EAST ANGLIA ONE NORTH

EAST ANGLIA TWO

Outstanding Biodiversity & HRA Issues Deadline 7 – 4 March 2021

SEAS (Suffolk Energy Action Solutions)

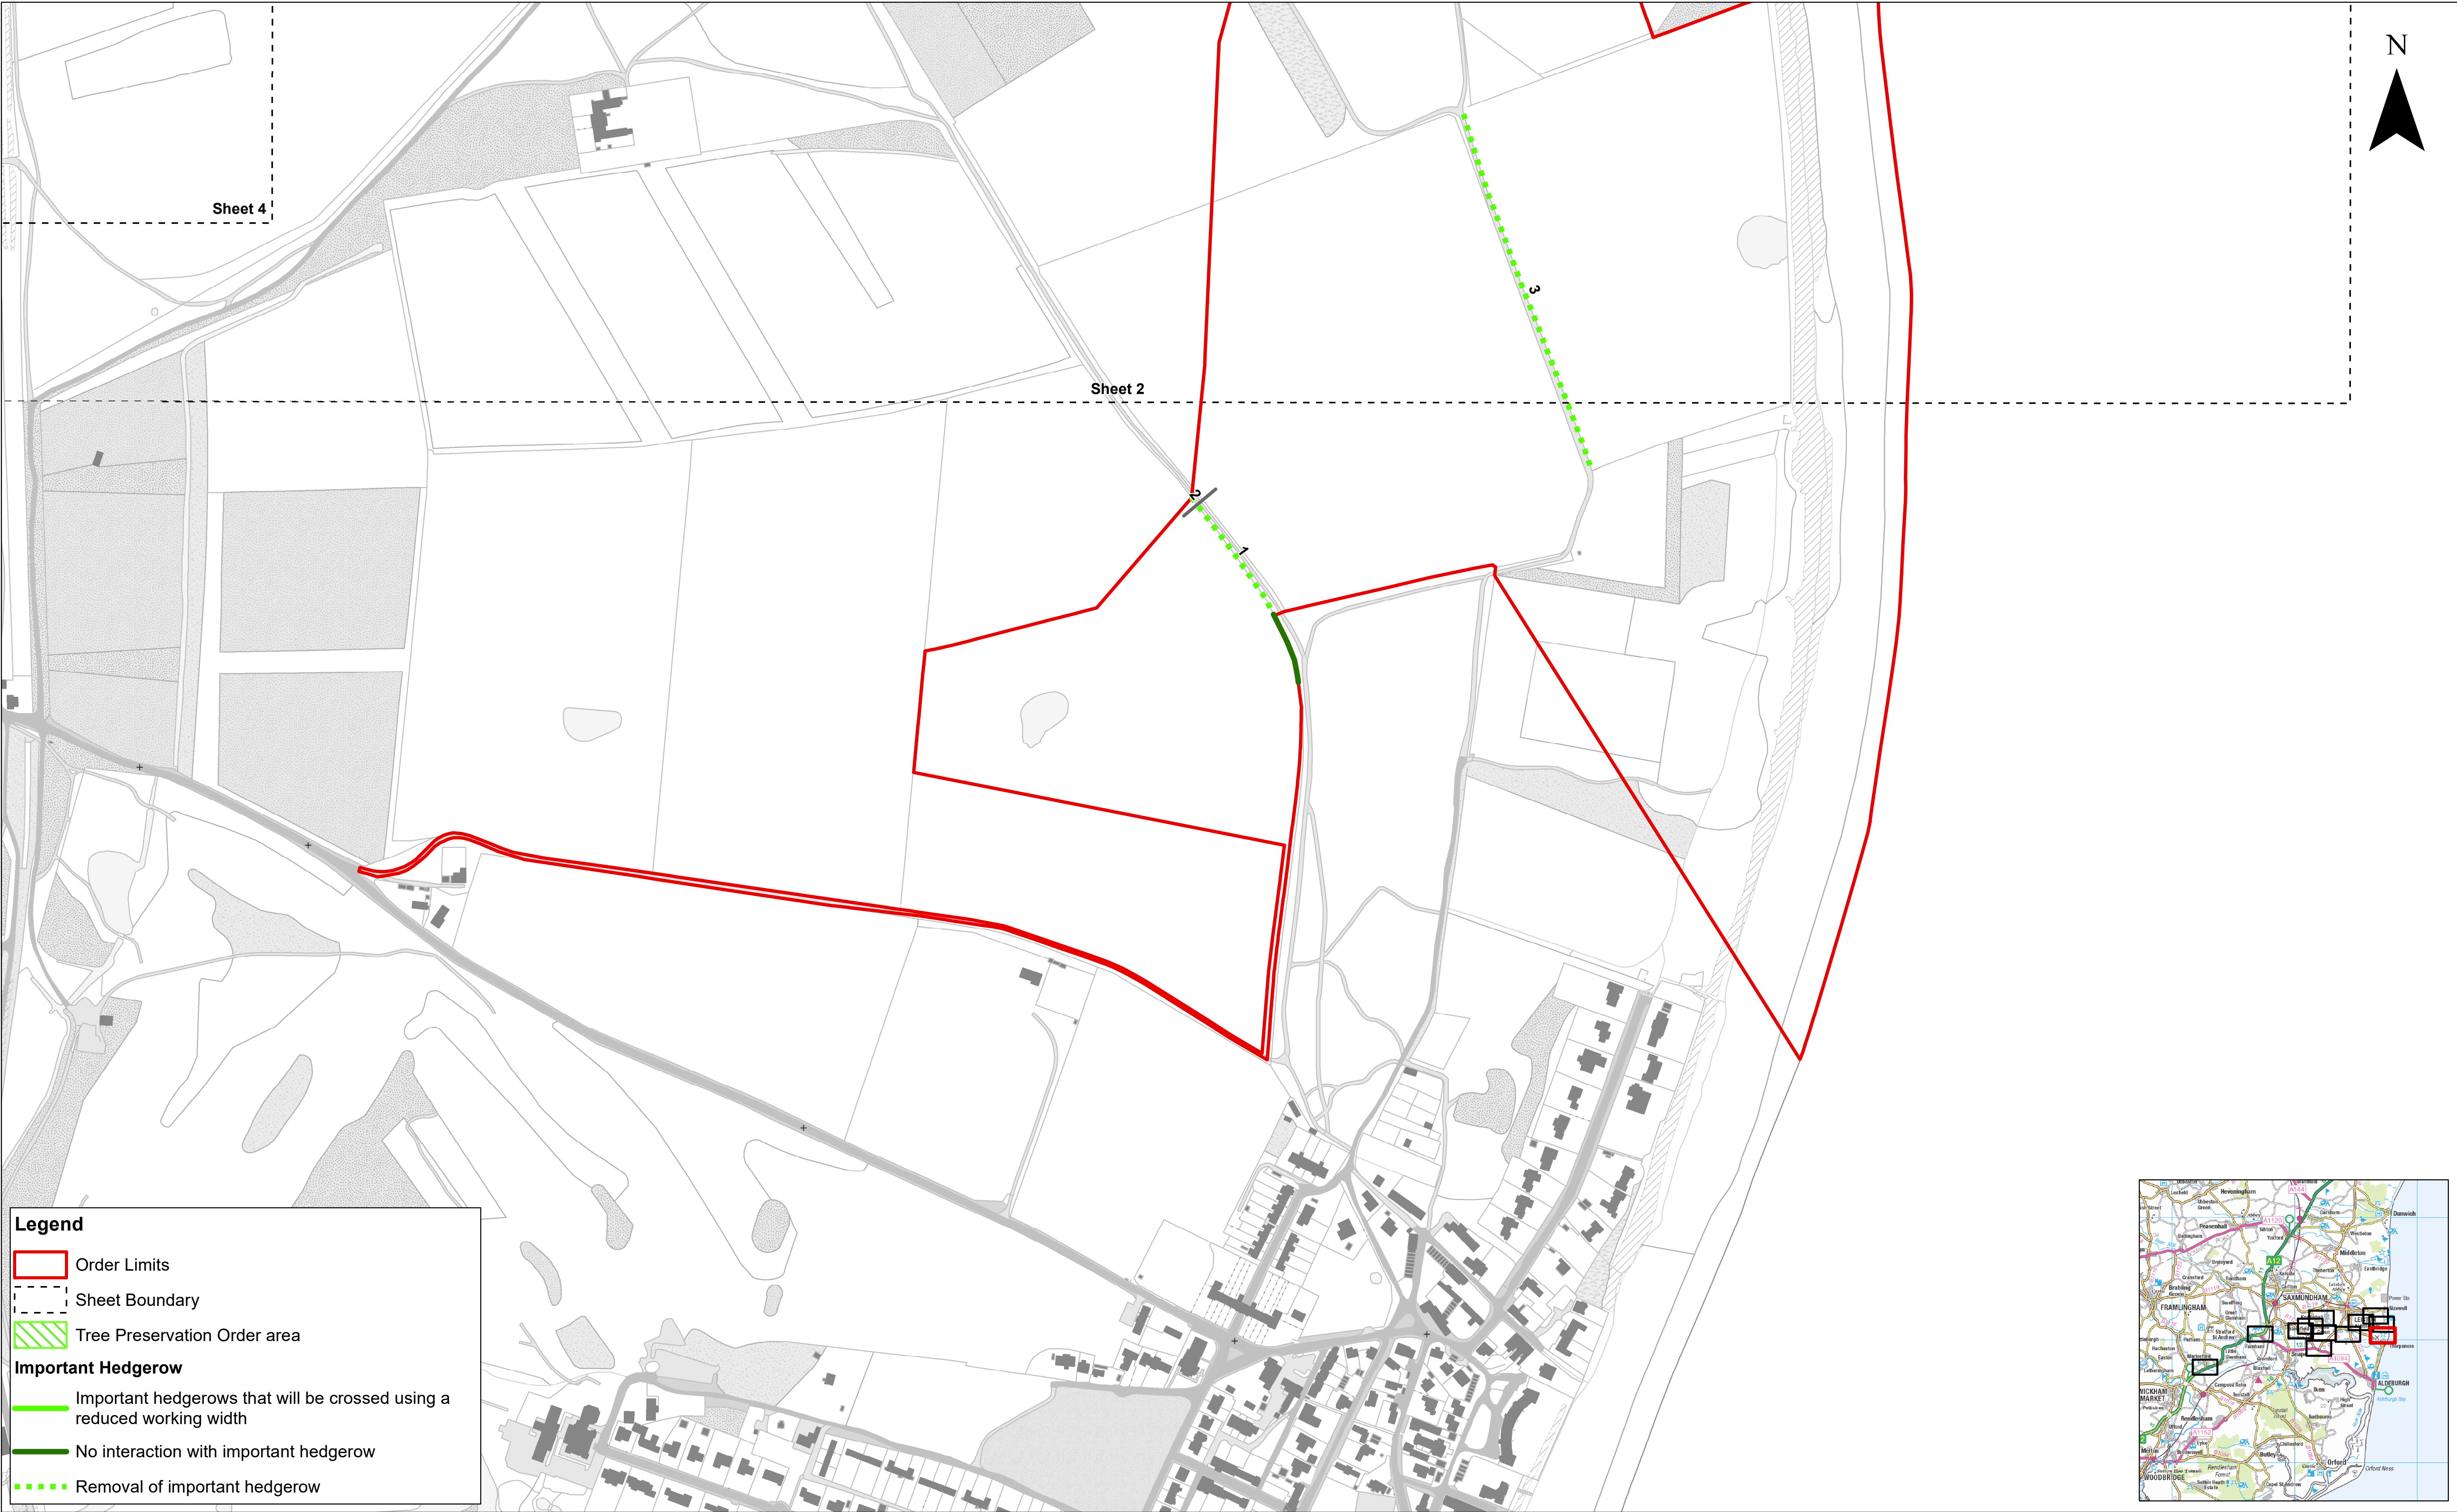
1. The Applicant has not addressed the problem of the important hedgerows in Aldringham and Coldfair Green, such as those that bound **both** sides of Fitches Lane. These boundaries are historic, and the hedgerows and their biome are around 2 centuries old.

2. SEAS is concerned at the lack of proper mitigation, and lack of scope for mitigation, for Area 19, Fitches Lane, and the all ancient hedgerows in the area. Treating a parallel hedgerow as a single hedgerow is not acceptable.
